**Your Ref: AOD/23/00105  
Our Ref: Z001763**

**North Selby Mine New Road Deighton York – Conditions 13,14,15 (foul and surface water drainage details) and 16 (public water mains protection measures) of 20/01546/FUL**

Title
Key plan

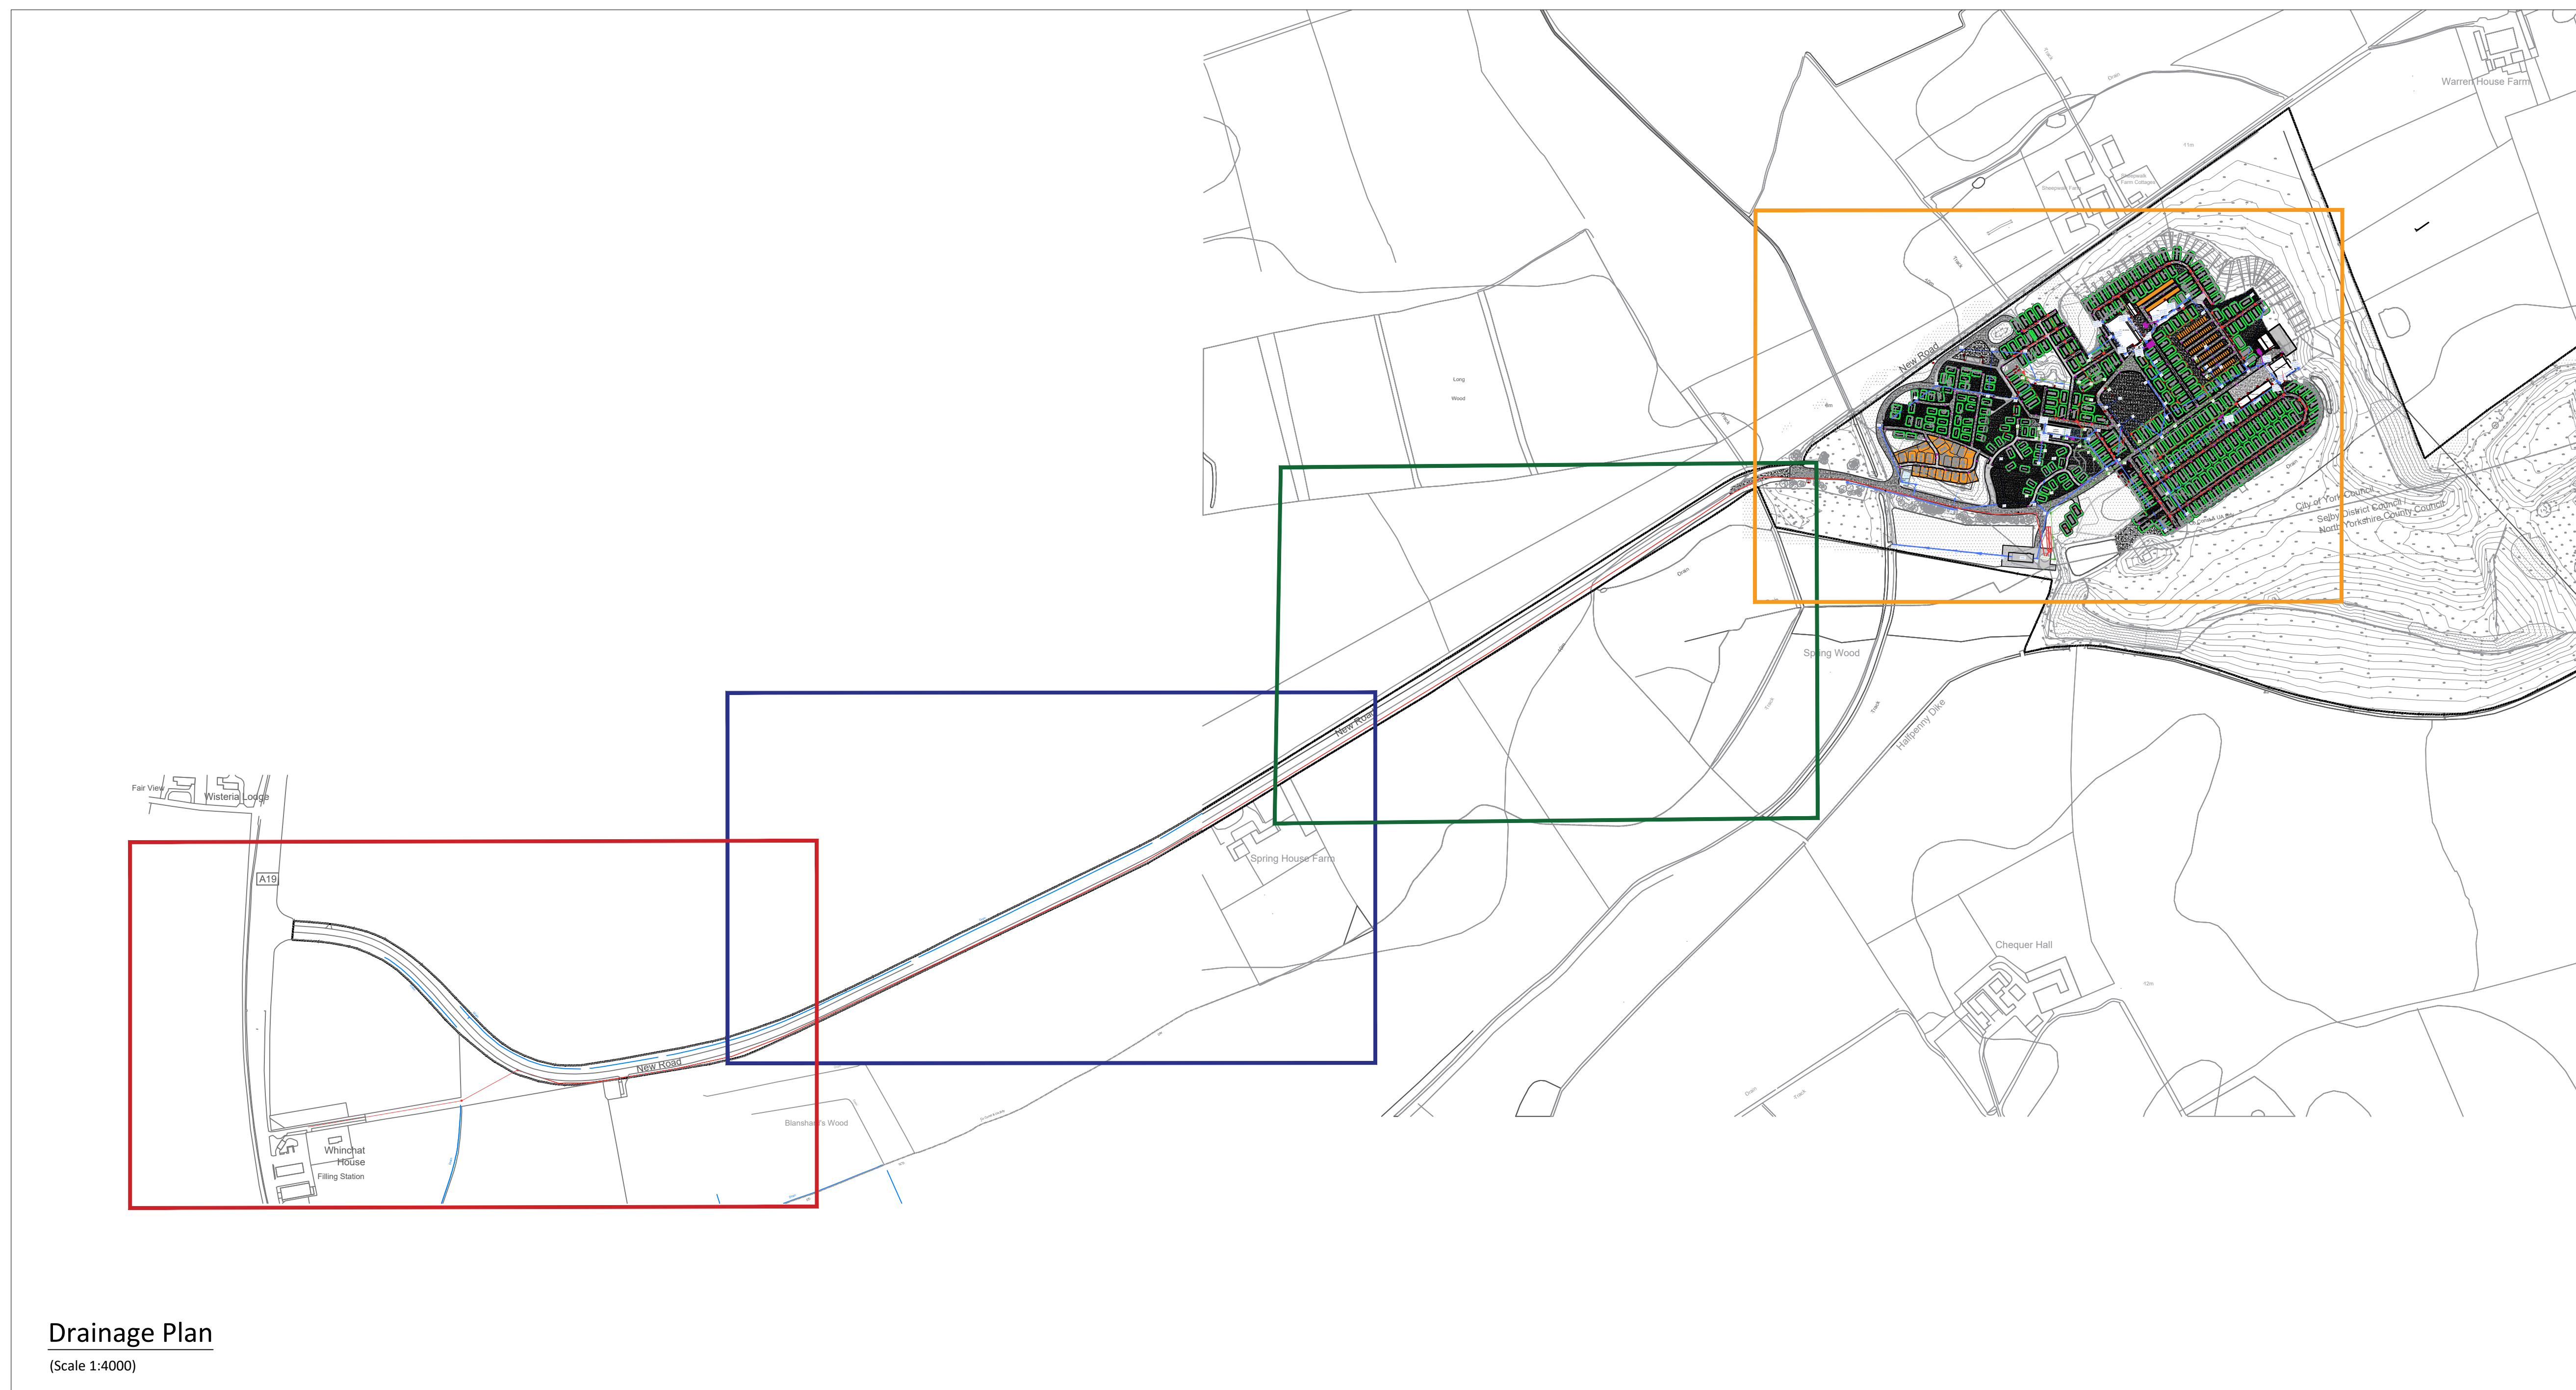
Application details show separate site for surface water and foul. Surface water will discharge to soakaway.

It is noted that the proposed foul water network will require a sewer requisition. This must be completed before the condition can be discharged.

There is a 6" and an 8" main that are within the proposed development, but these seem to be in roads and footpaths so may be unaffected by these works. However closer details will need to be provided to ensure these mains are adequately protected.
